Please ask for: Nicola Moore
Email: nicola.moore@arun.gov.uk
Telephone: Ext 37944
Our Ref: BR/122/20/OUT
Your Ref:
Date: 31st July 2020

Application for Outline Planning Permission

Development: demolition of garth house and west view to be replaced with 20 self contained apartments
Location: Garth House High Street Bognor Regis PO21 1HQ

1:200 1:1250

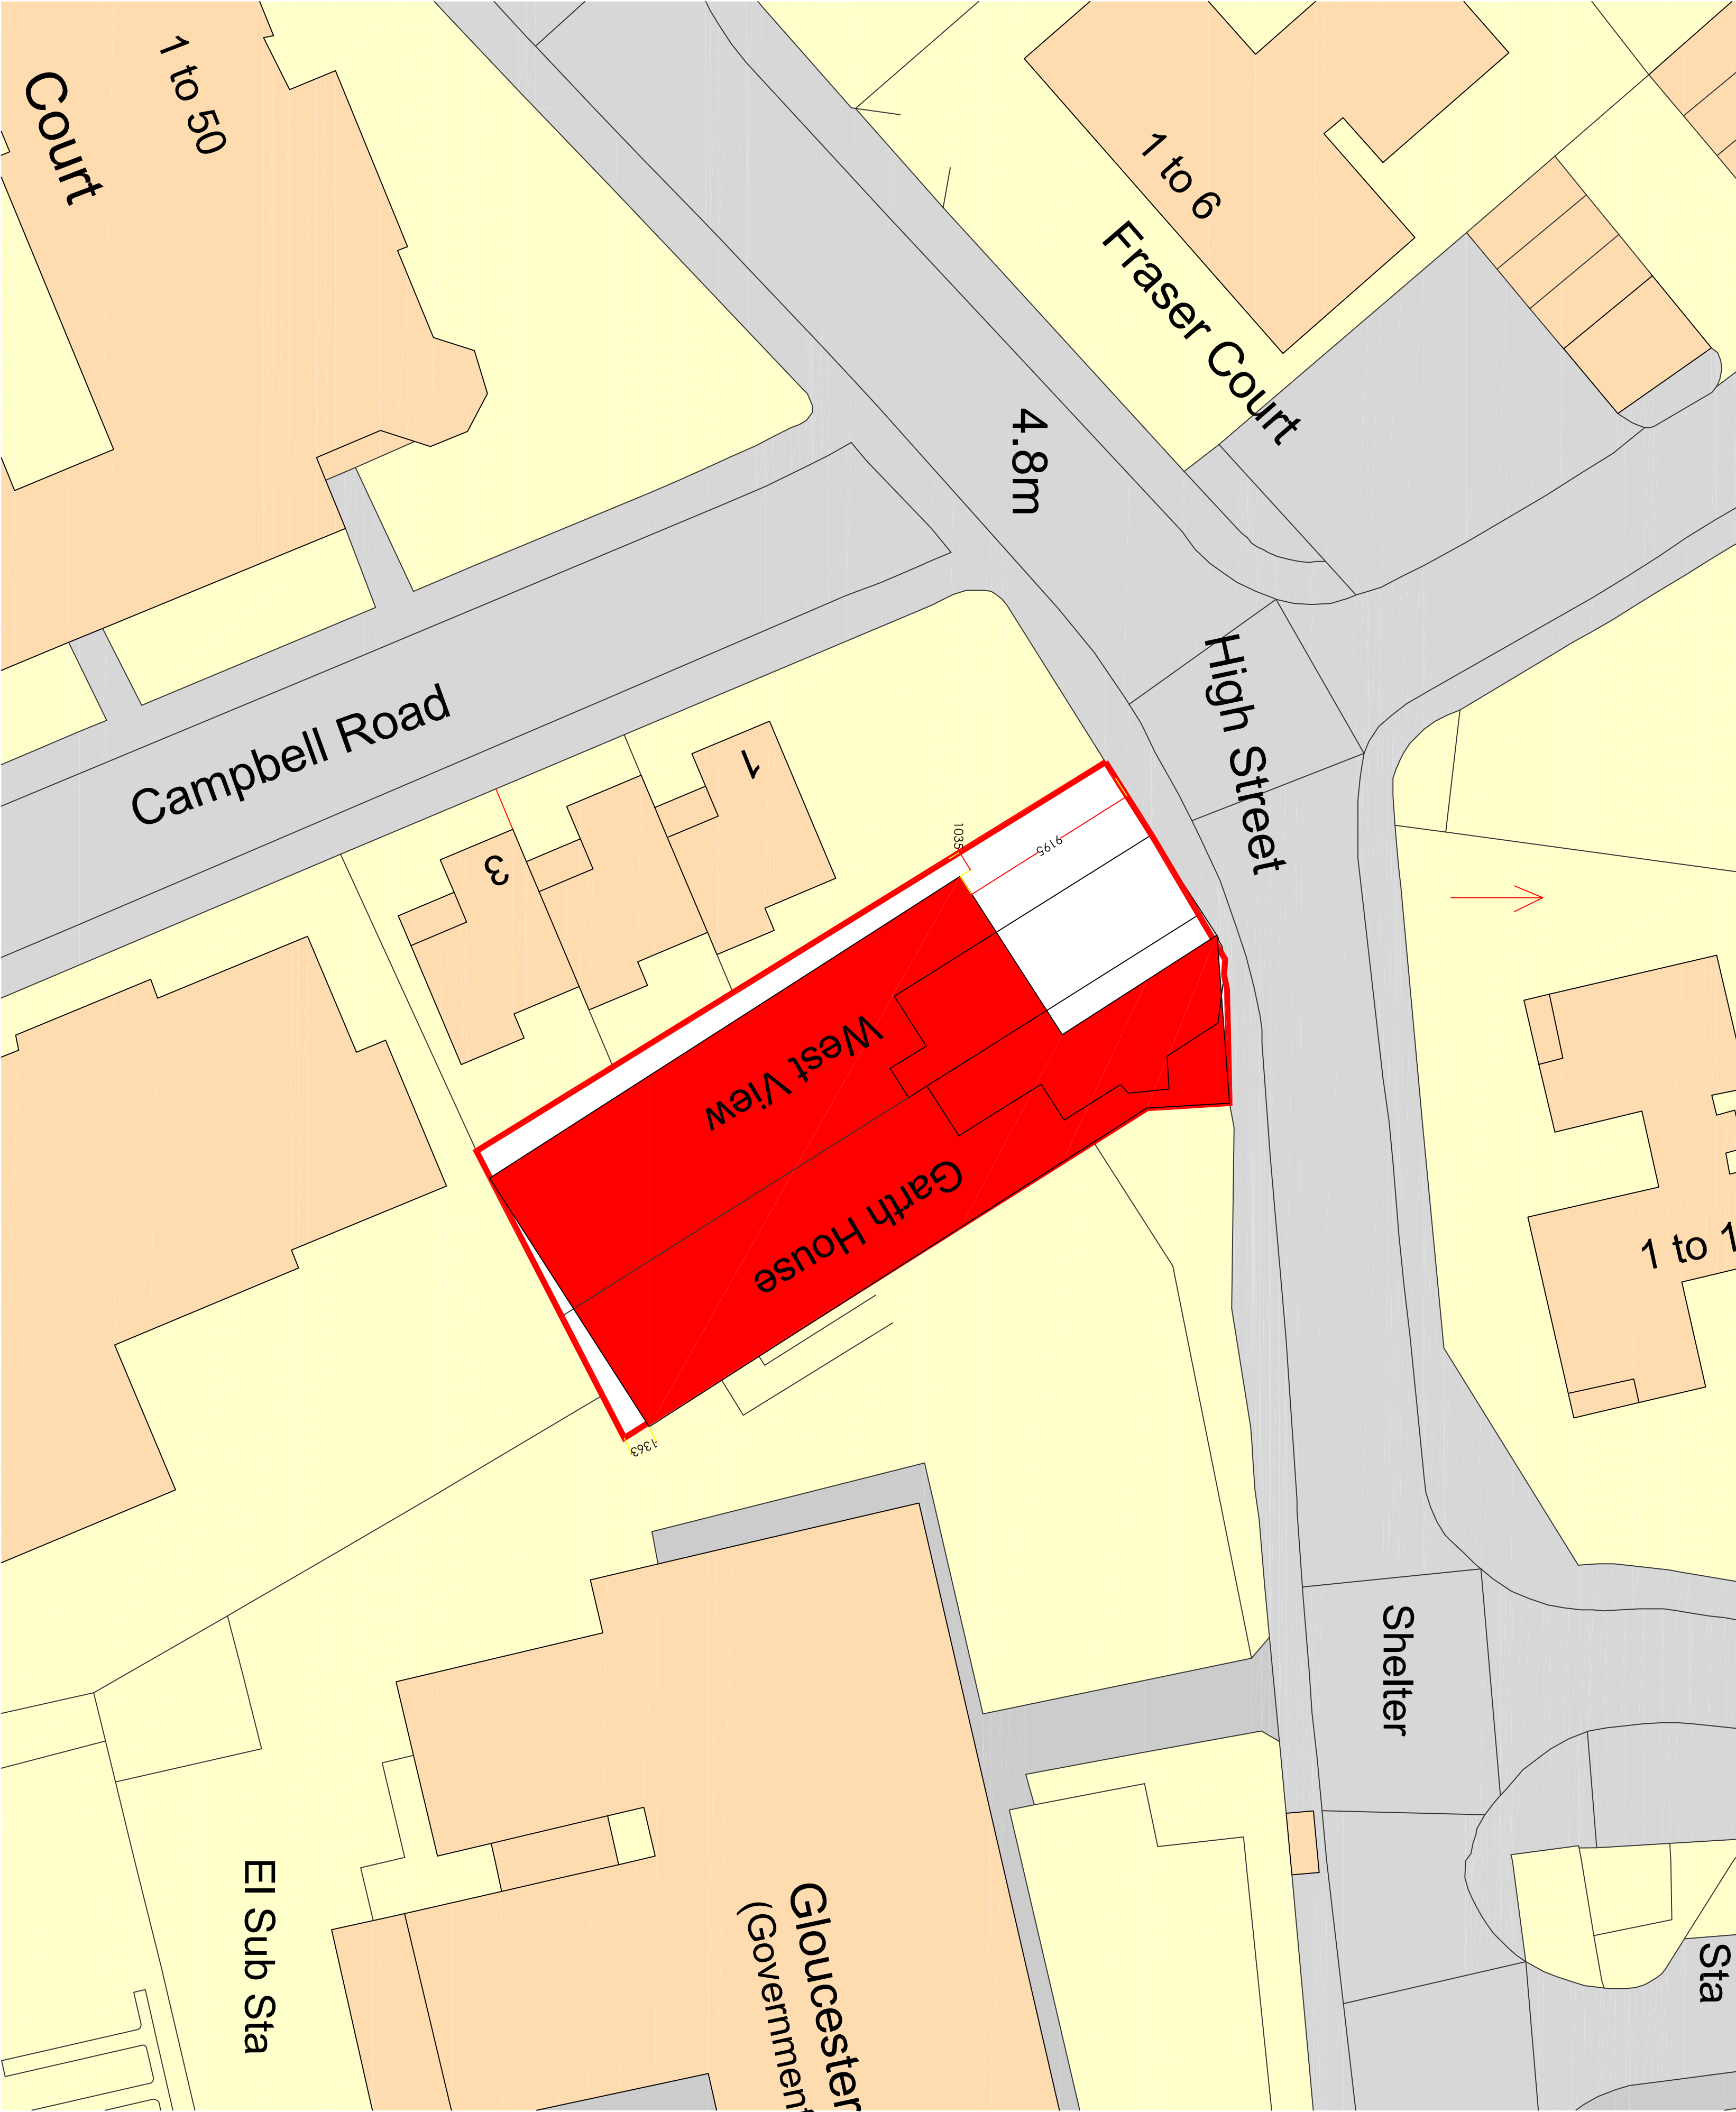
Block Plan

Please amend the Block Plan to show the direction of North and remove red edges that are not applicable to the application site. The Block plan should also include the footprint of the demolished building/s and all measurements to boundaries of the proposed development. Please submit at a scale of 1:500 or 1:200
